PLOT PLAN
(THIS IS NOT A PROPERTY SURVEY)

PROPERTY ADDRESS: 11235 S. HOLMES RD.
COLORADO SPRINGS, CO

Site Plan v_1.pdf Markup Summary

PLOT PLAN
(THIS IS NOT A PROPERTY SURVEY)

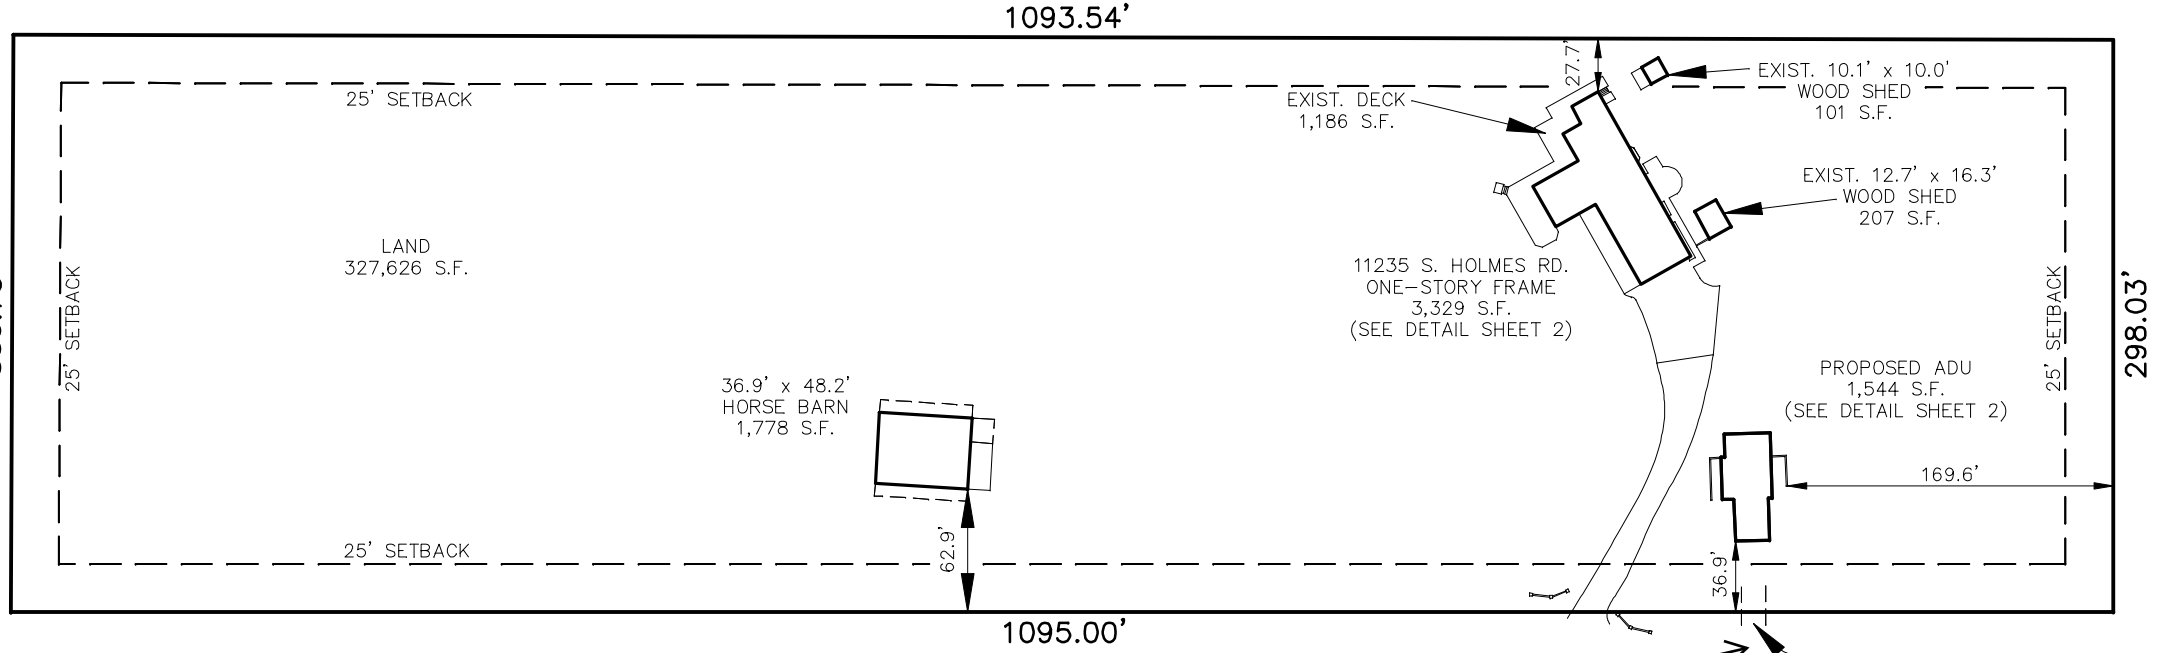
Please include all easements items noted in title commitment.

Max. ALQ size is 1,500 SF. Habitable area is used to calculate the maximum allowance; please revise to show that the habitable floor area is no more than 1,500 SF. Please note that areas such as storage, unfinished garage, etc. can be excluded from the habitable floor area calculation.

Suggestion: Separate habitable area from overall floor area in the "ADU/ALQ" calculation. Even just removing the mechanical closet from the ALQ floor area calculation would make the SF compliant.

Please add height of all existing and proposed structures.

Remove proposed entrance and use existing driveway.

327.626 SF = 7.52 acres. Assessor shows property is 7.43 acres in size. Please revise or show evidence of property being 7.52 acres.
